Rezoning Transportation Analysis

Petition Number: 2023-029

Date	Description
06-28-23	First Review (TM)
07-28-23	Second Review (TM)

**SCHEMATIC**  
**SITE PLAN**

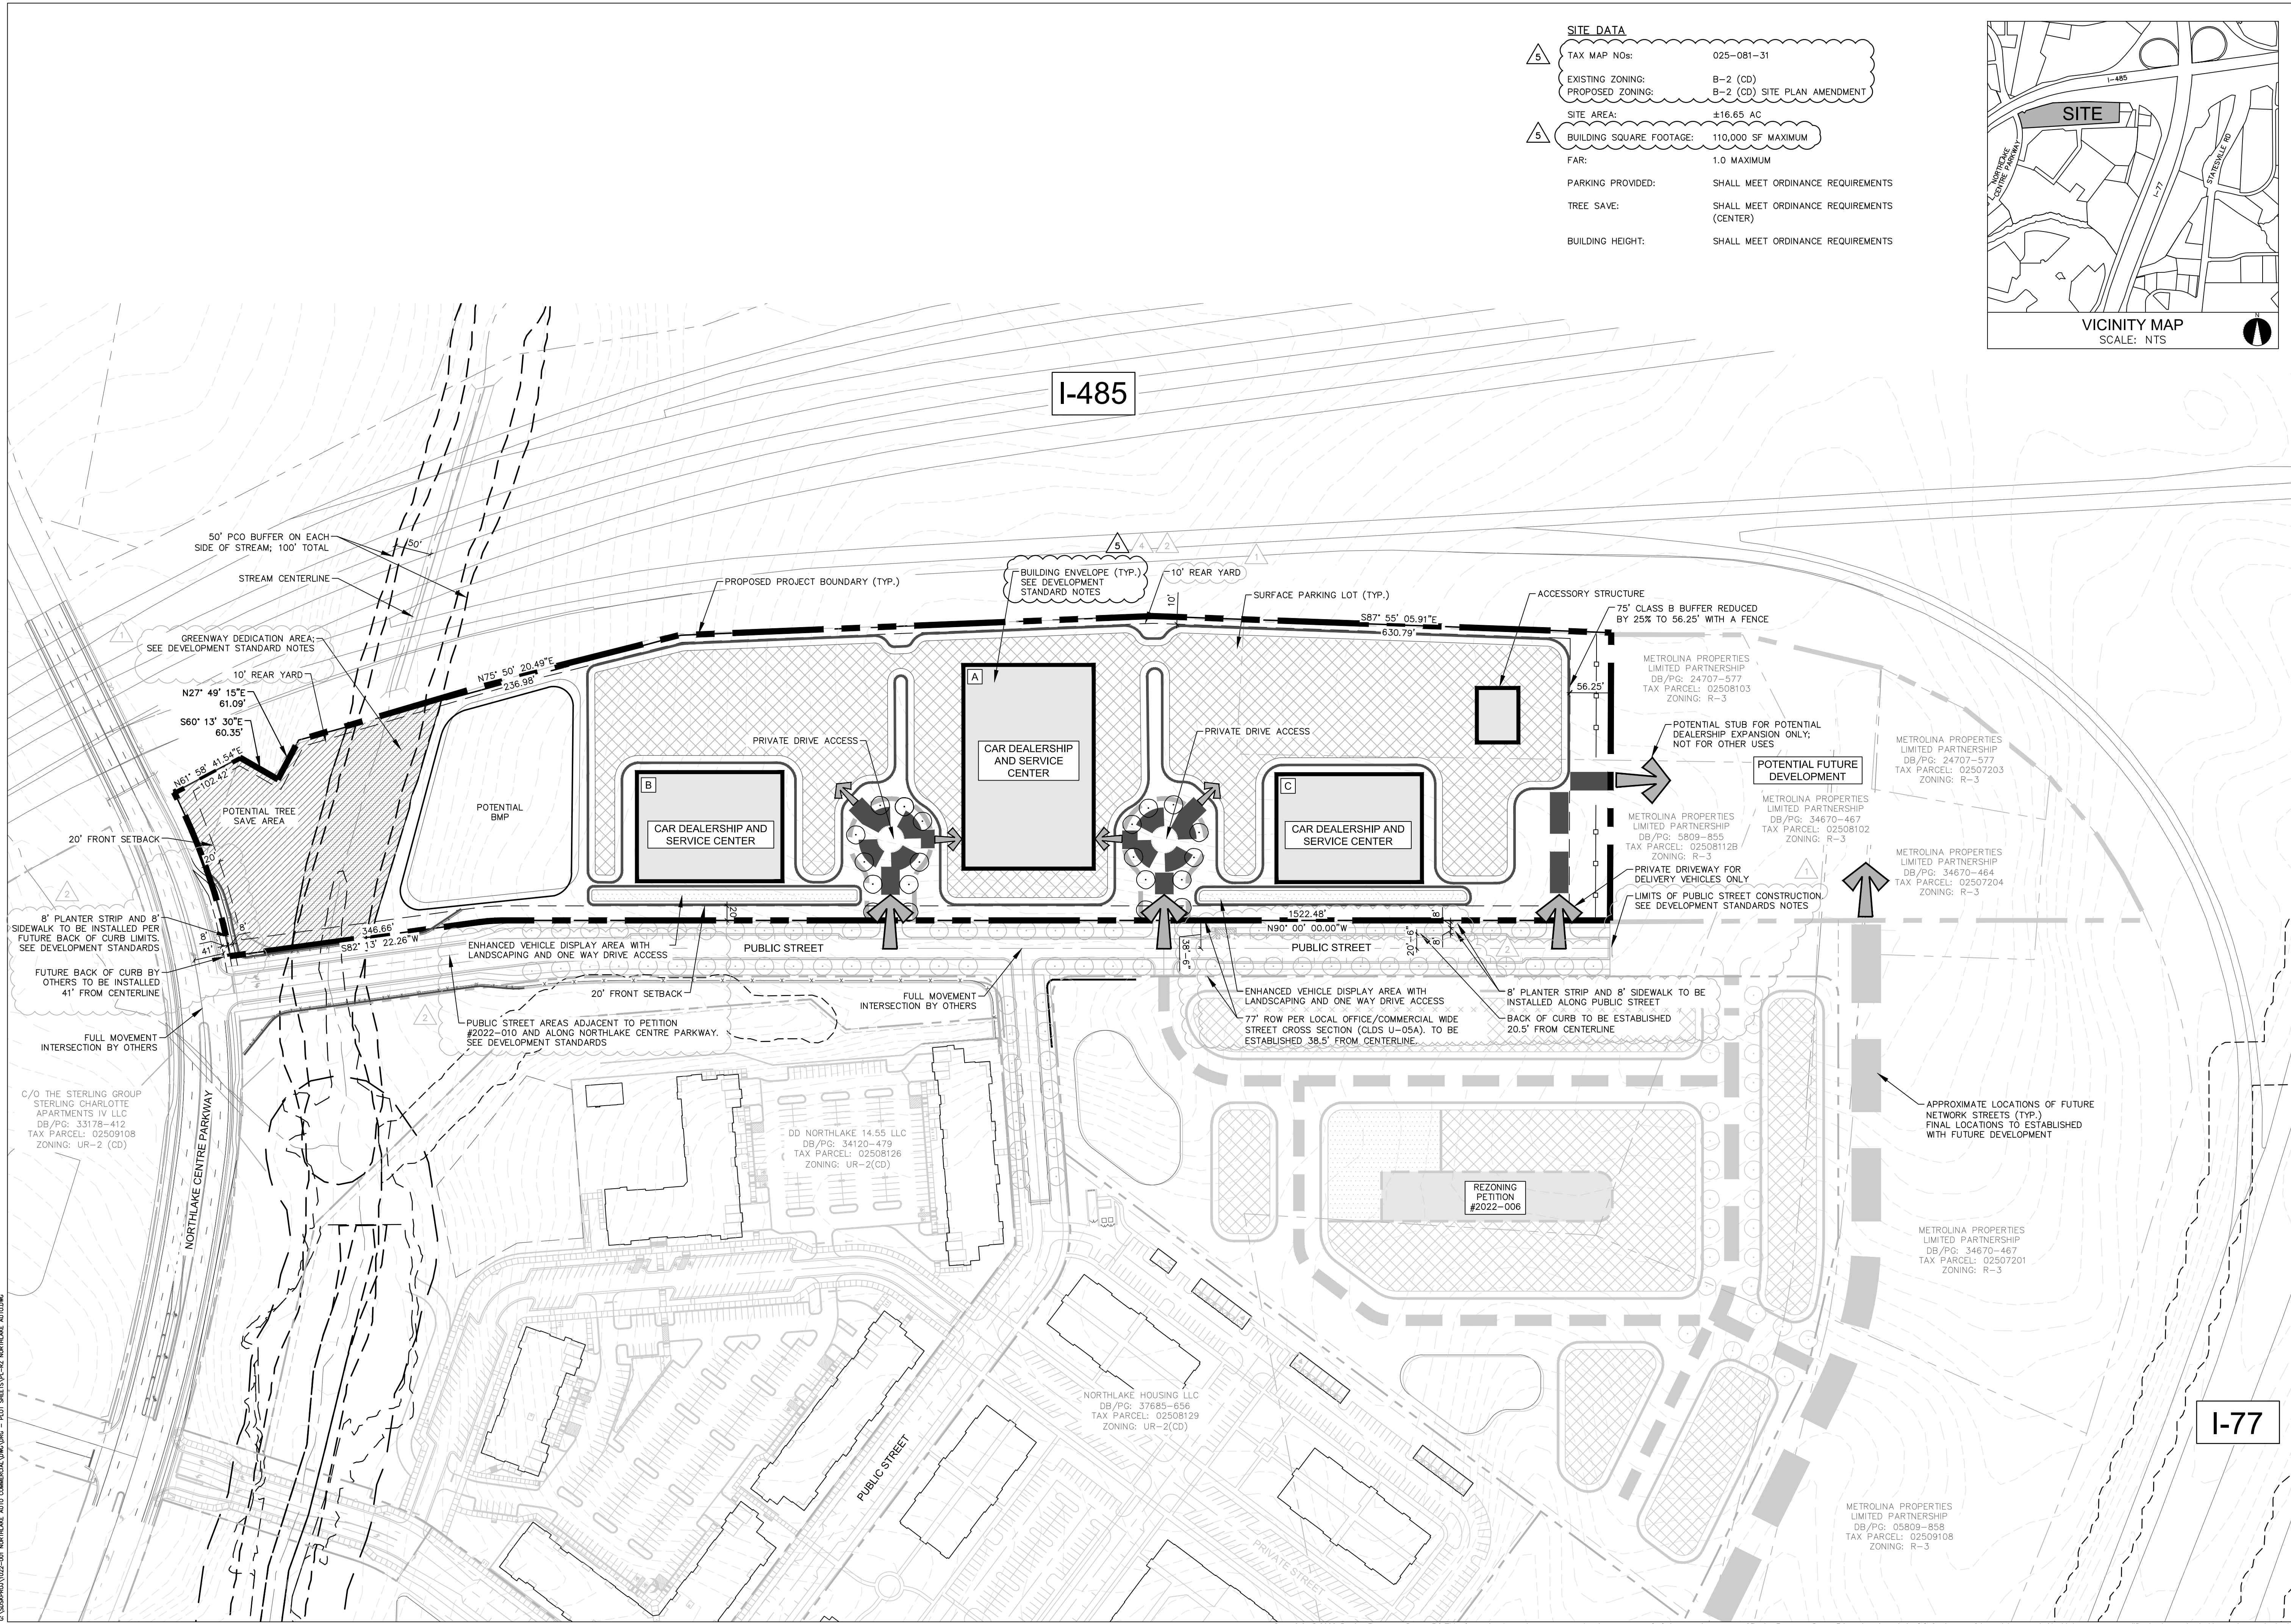
1. ~~**Curblines:** The proposed zoning district has a setback measured from back of the existing or proposed future curblines.~~
 - a. ~~**Northlake Centre Parkway:** Location of the future back of curb and gutter is 41 feet from the centerline of the roadway. Label the future back of curb location on the site plan for planning purposes. The existing curb line will not be required to be relocated for this petition.~~
 - b. ~~**Proposed Public Streets:** Location of the back of curb and gutter will be established at 20.5 feet from the proposed centerline of the proposed public streets per CLDSM U-05A for a commercial wide street typical section.~~

~~NOTE: Additional distance from center line to back of curb may be required in locations where a median is present or around intersections and interchanges.~~

~~Label and dimension the curb and gutter from the centerline for each road on the site plan.~~

2. ~~**Traffic Study:** An updated Technical Traffic Memorandum is needed due to the increase in trips associated with the proposed rezoning. Provide an updated TTM for review.~~
3. ~~Revise site plan and conditional note(s) to commit to adding a conditional note stating the annexation plans of the public roadway regarding maintenance of the public roadway.~~
